Application for Reserved Matters application following Outline Planning Permission AL/39/13 for the demolition of Oakdene and all other structures within the site and the erection of 79 dwellings, public open space, children's play areas, landscaping, drainage measures, sub-station, pumping station and all other associated works.

Land West of Westergate Street & East of Hook Lane Westergate

Thank you for your internet representation made on 7th November 2016 which has been recorded as '**an objection**' with the comments as follows:

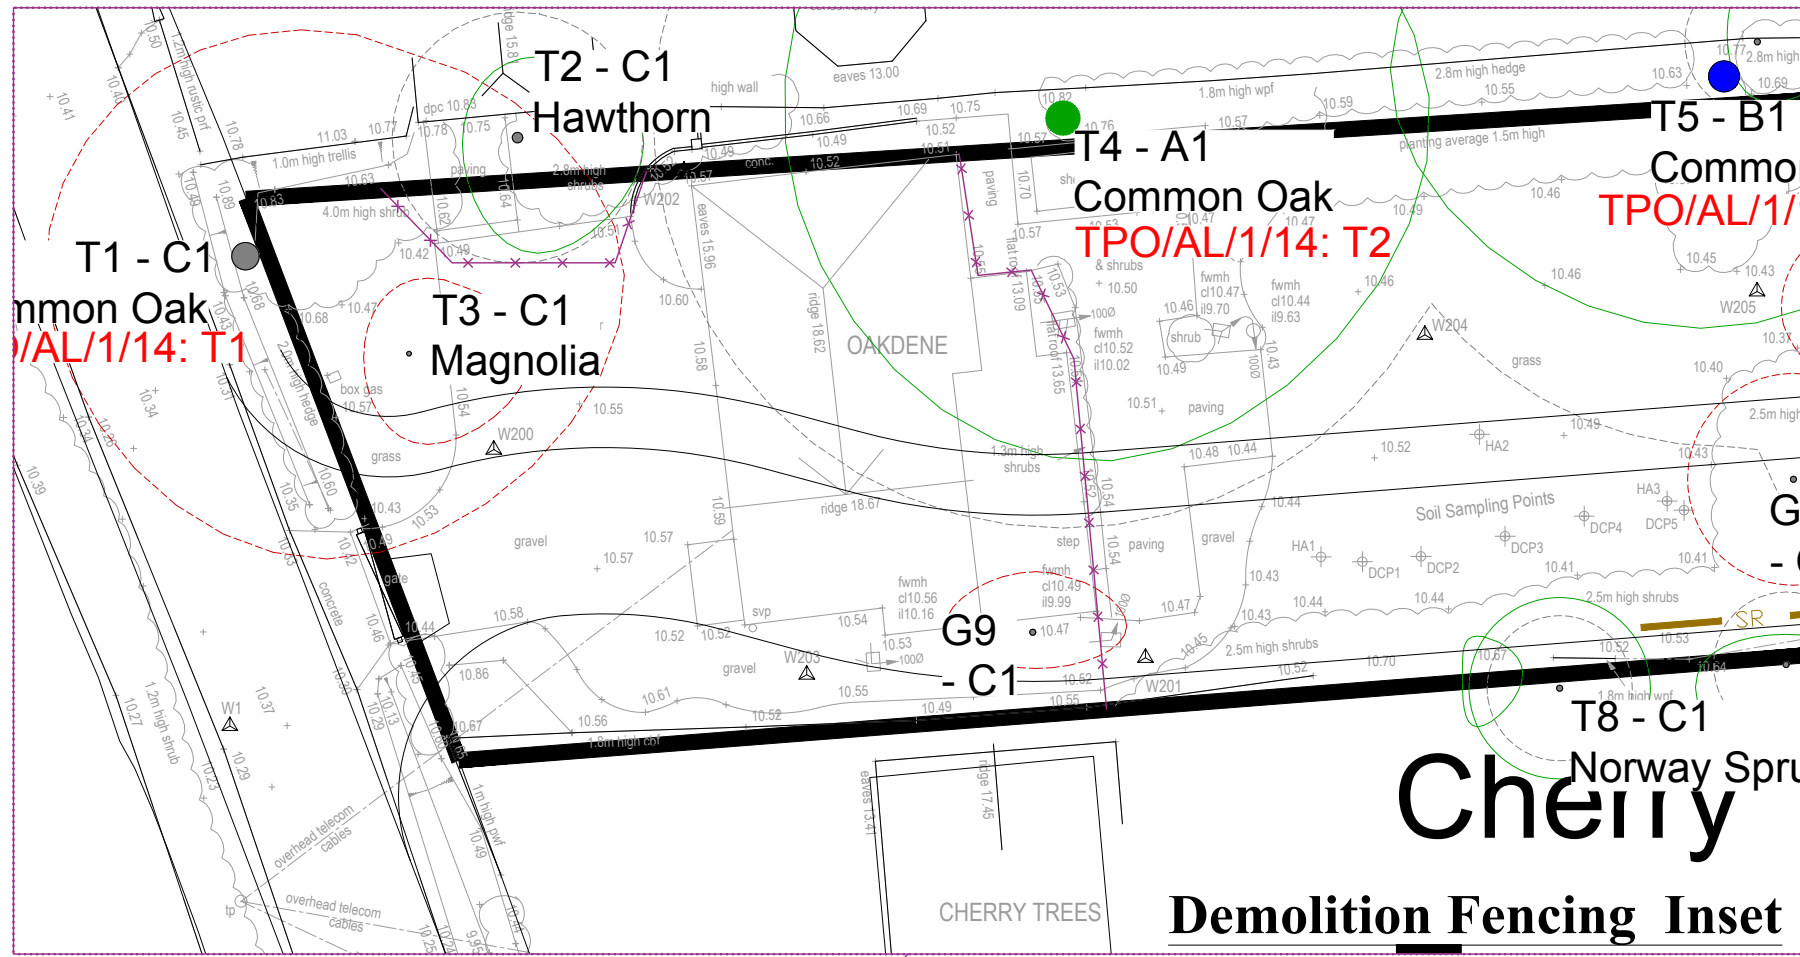
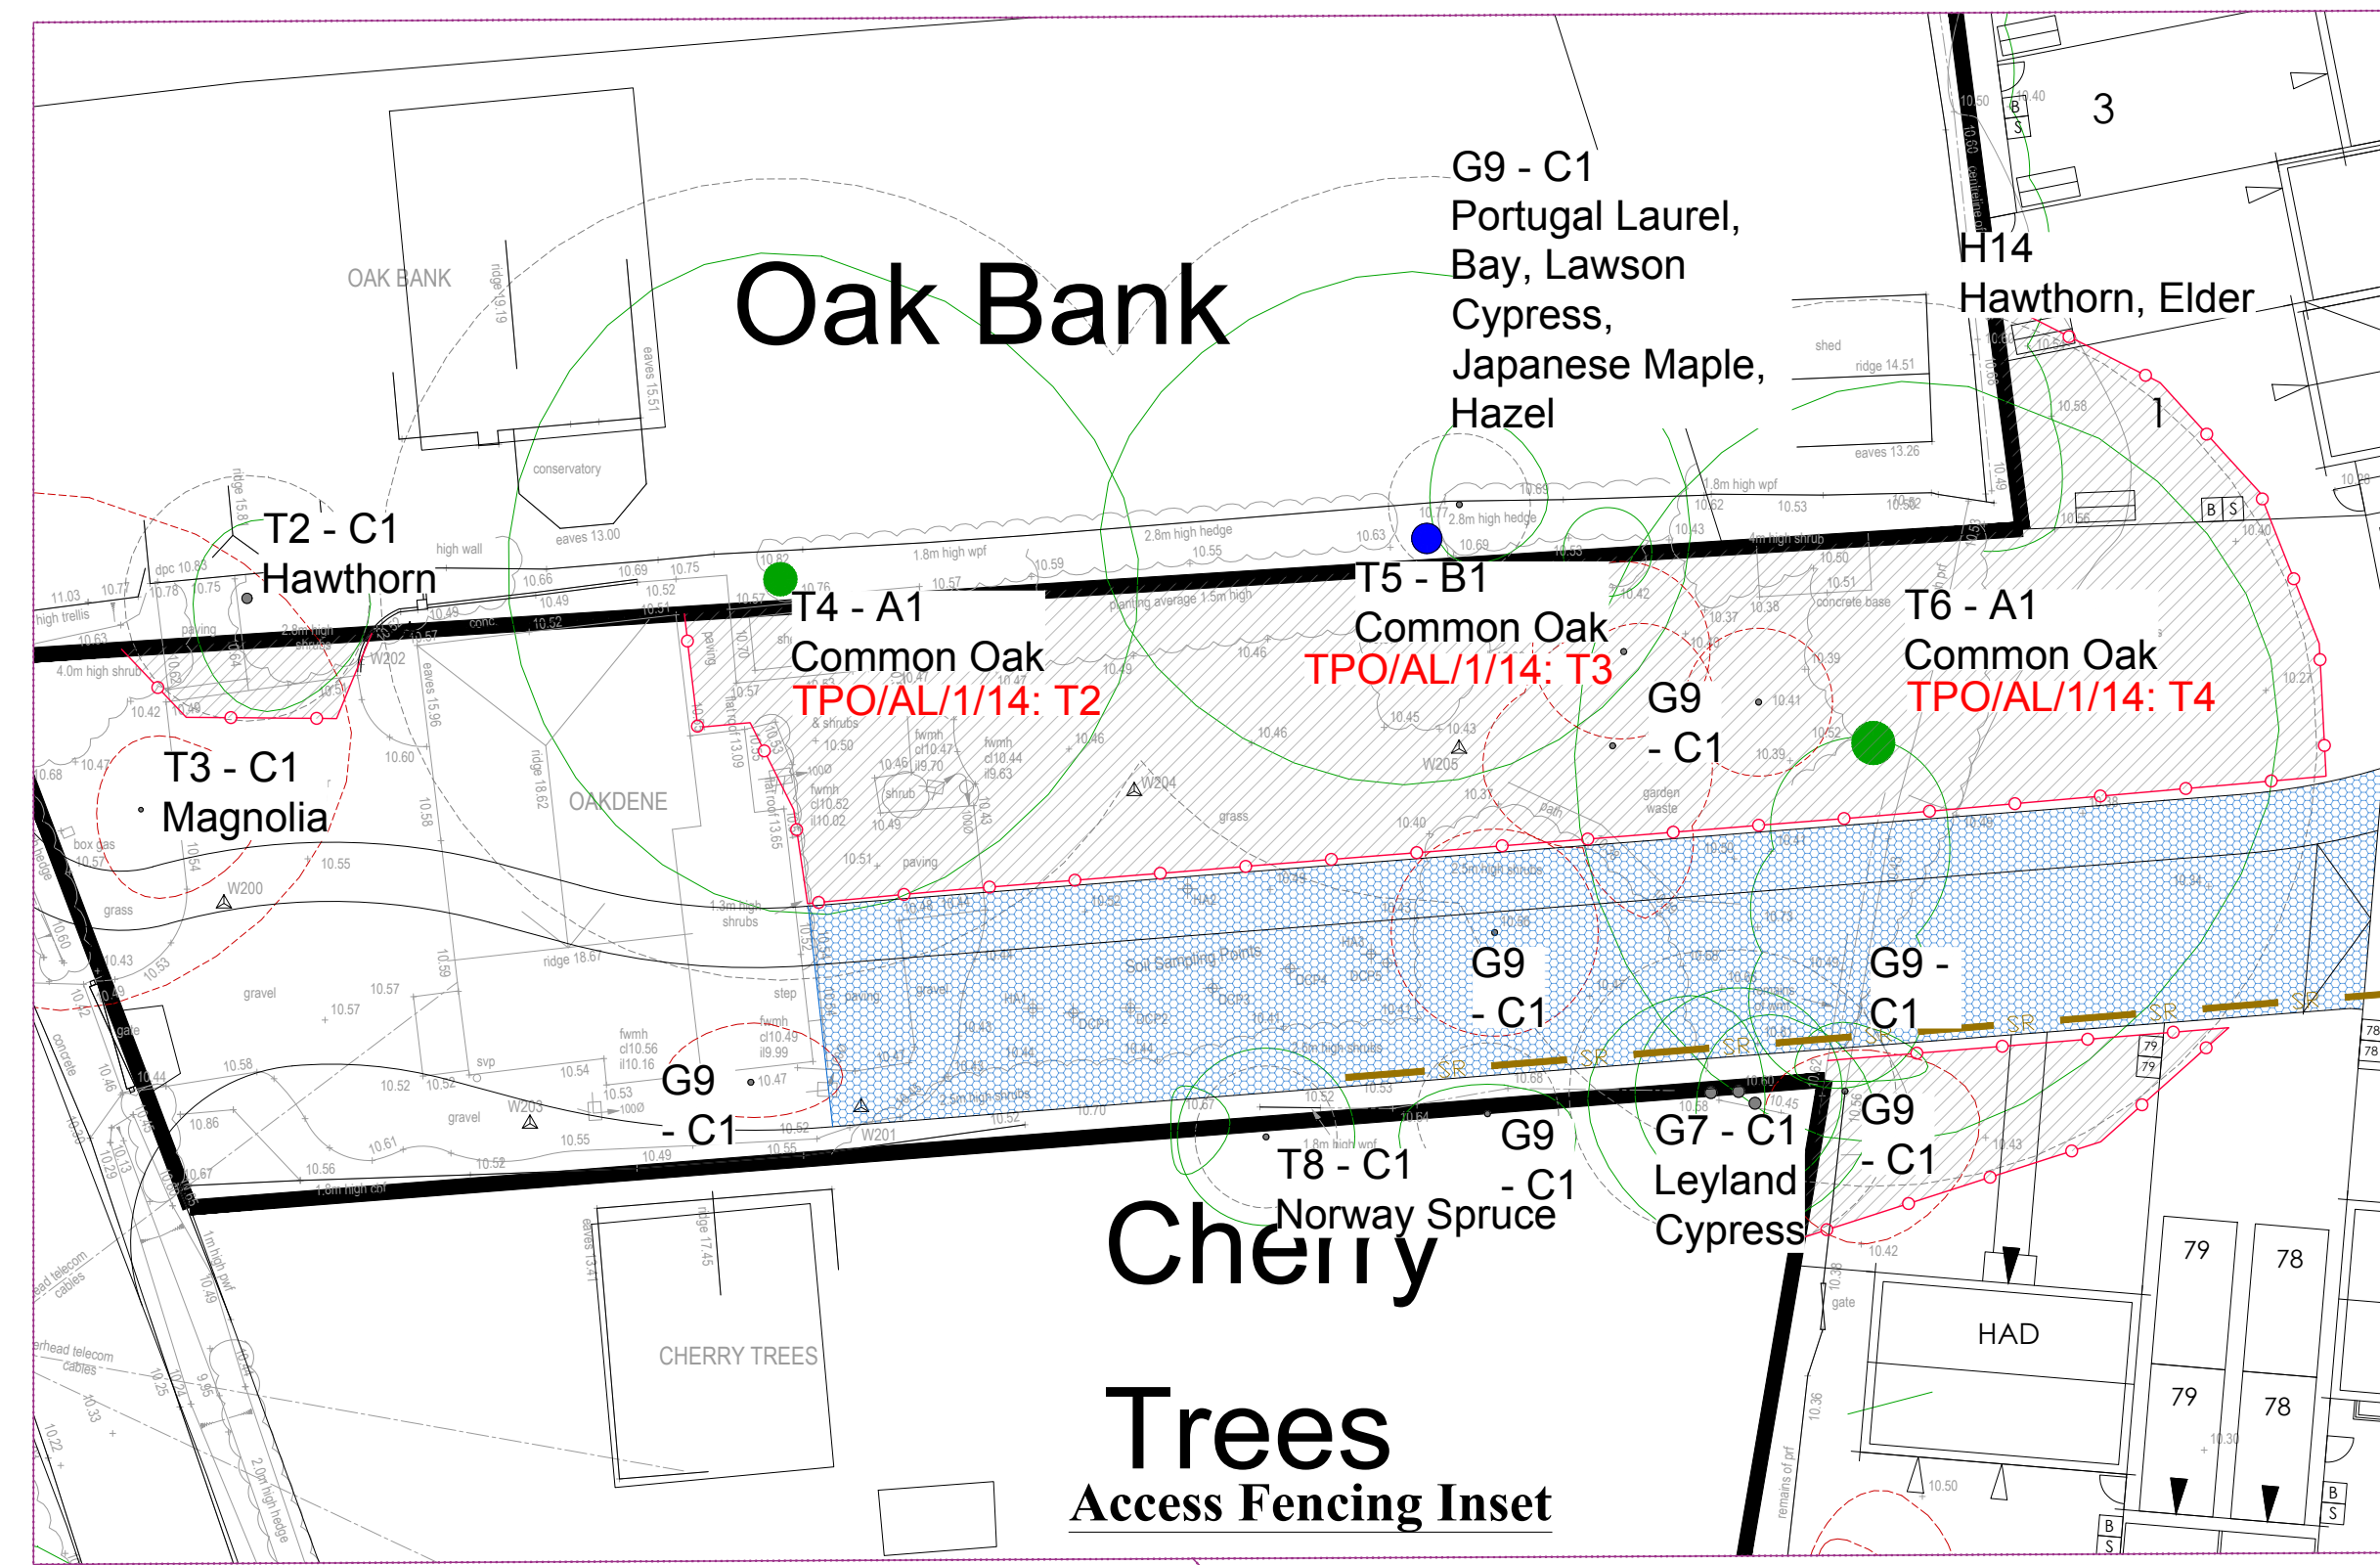
Re, Revised Tree Protection Plan. A protective hedge fence is being shown to the east of Kittenash, but no protective fencing to the hedge at the southern boundary. This fence must be to the south, as well as the east boundary
